29 FLORIDA STREET  
SYLVANIA (SSD-83258708)

RESPONSE TO SUBMISSIONS

REVISION 04

26.03.26

TYPICAL APARTMENTS -
MARKET BUILDING 1B

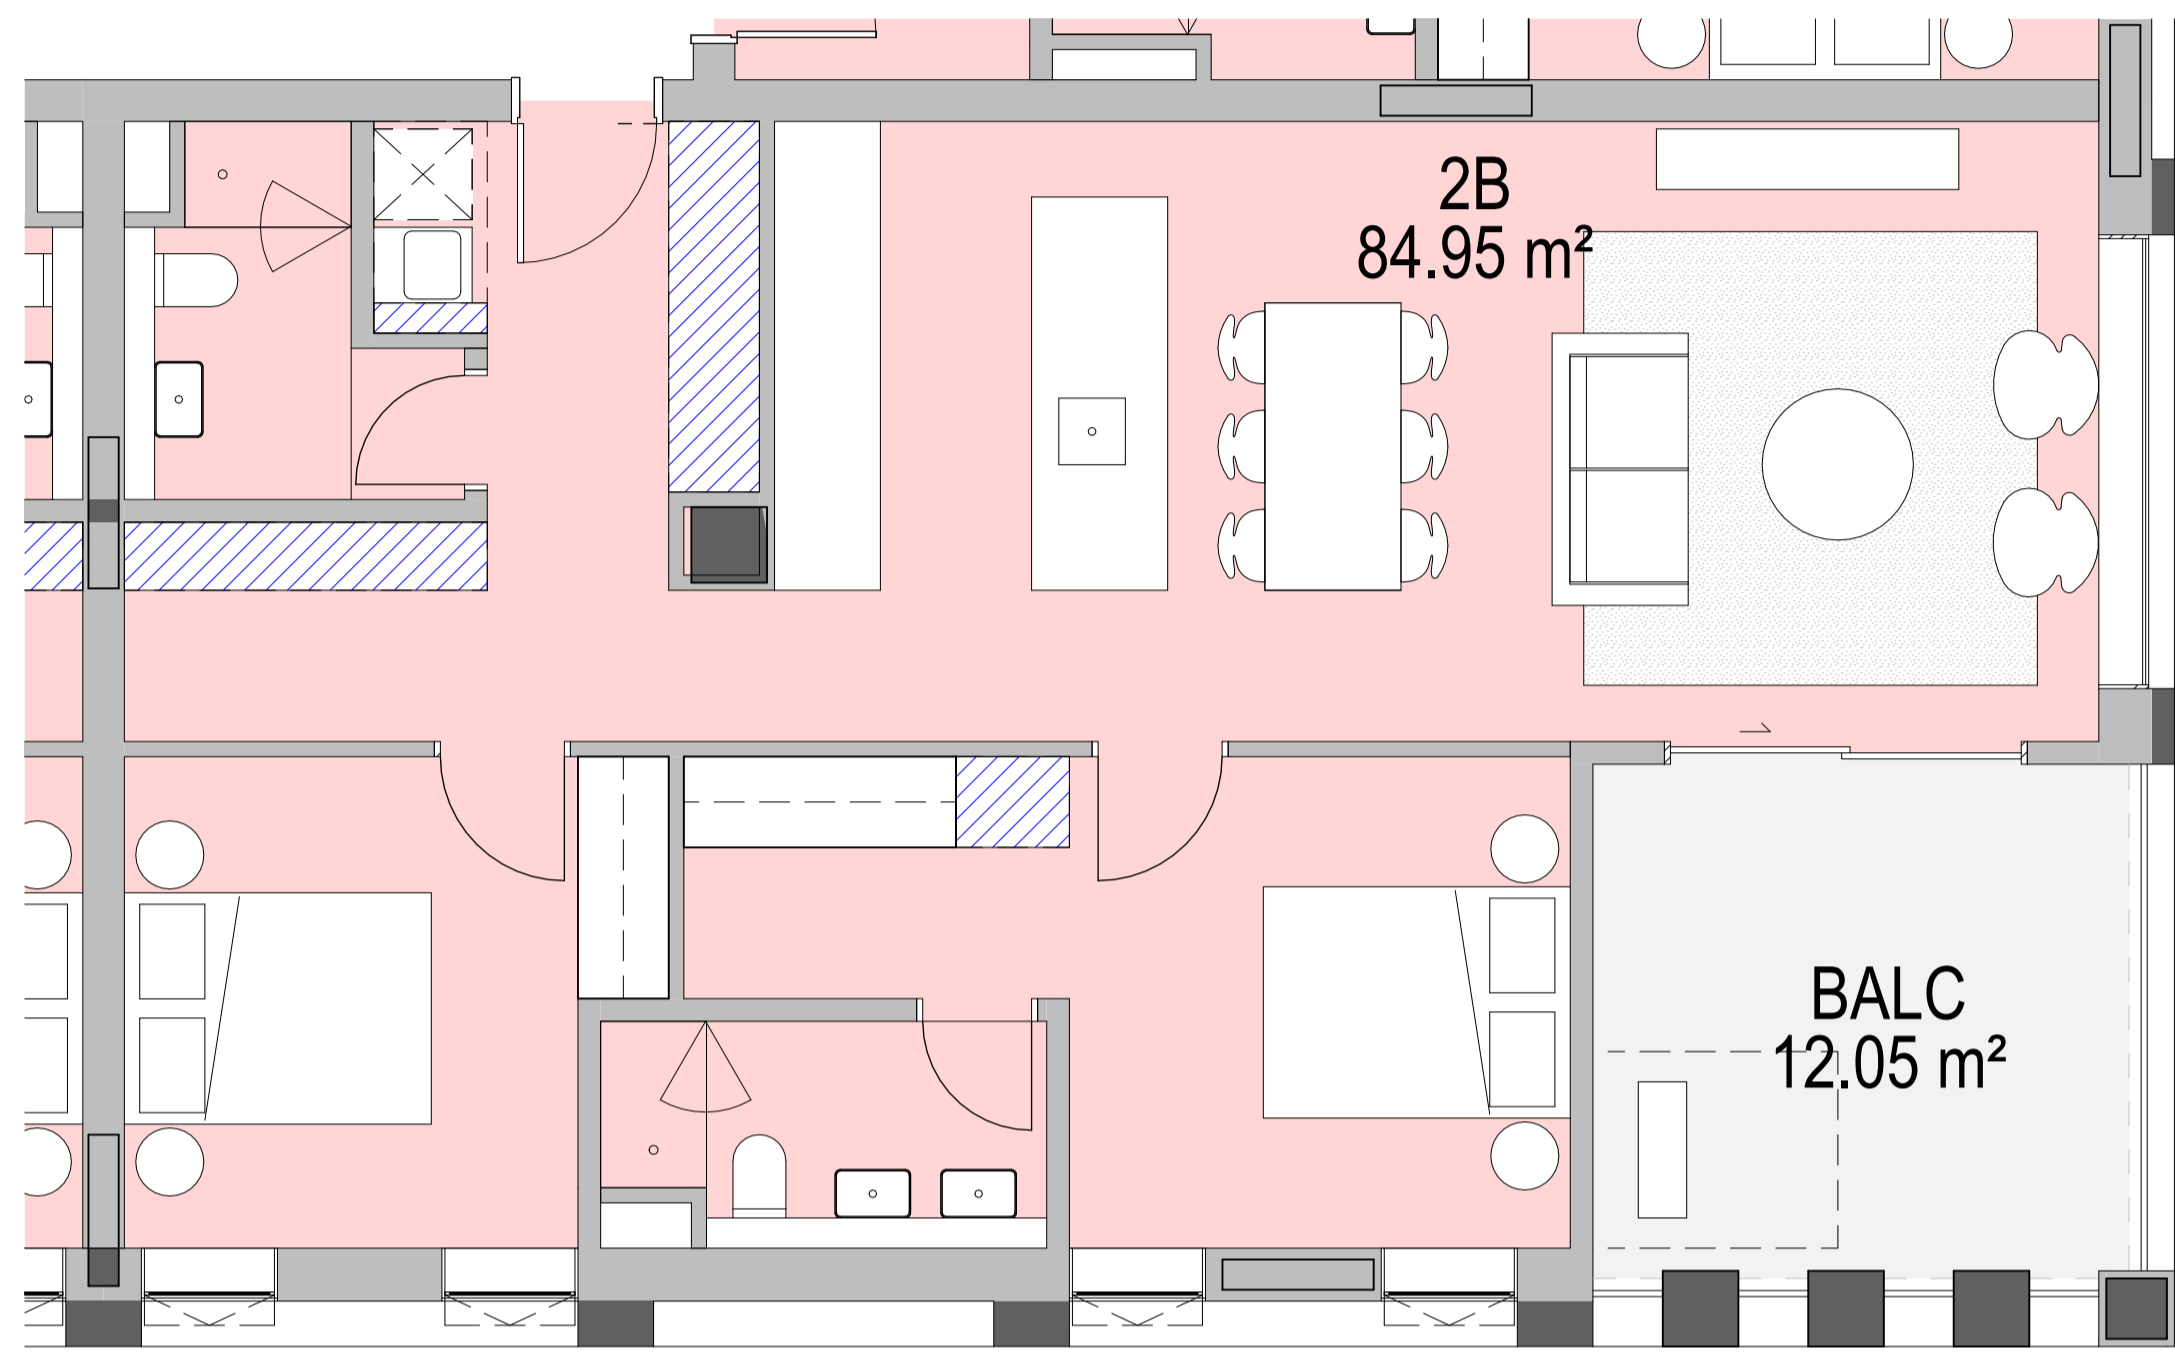
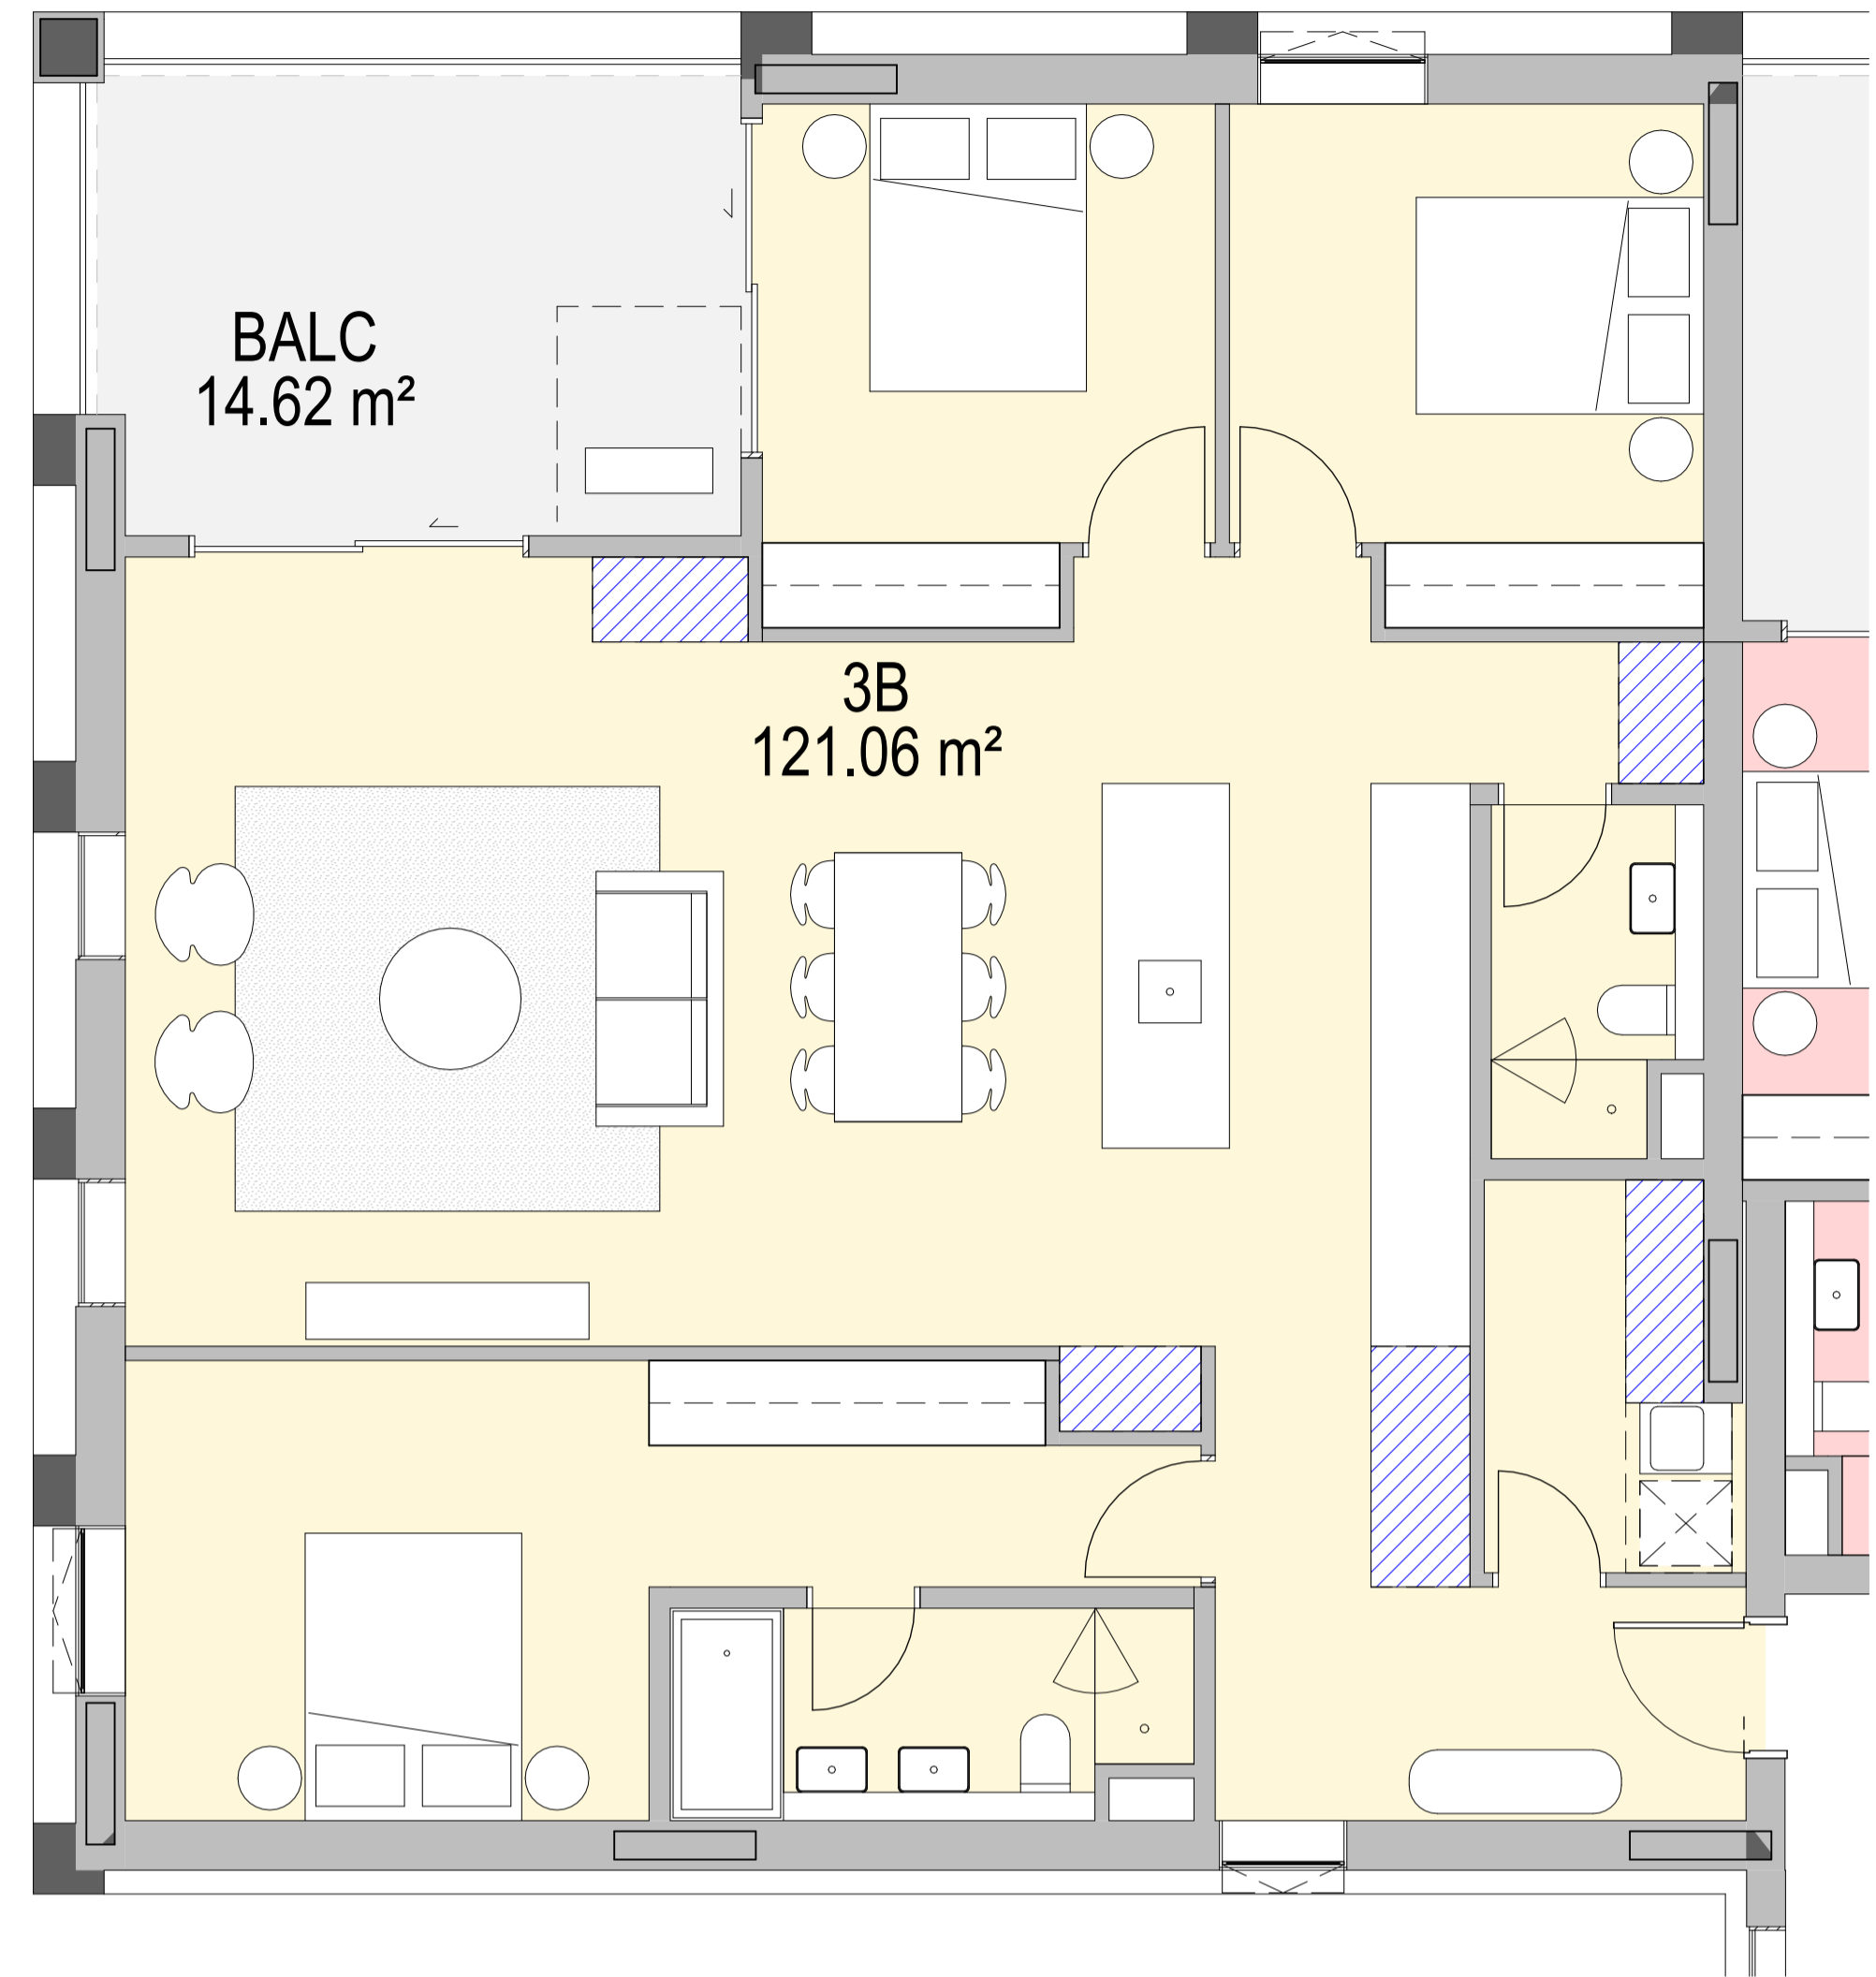
NO.	ISSUE RAISED	RESPONSE
BUILT FORM & URBAN DESIGN		
5.4	Provide annotated dimensions on plans that demonstrate all apartment sizes and layouts, and private open space areas are functional and provide a high standard of amenity having regard to the relevant design criteria of Part 4 of the ADG, specifically, Part 4D and Part 4E.	Annotated dimensions have been shown on plans for typical apartments below.
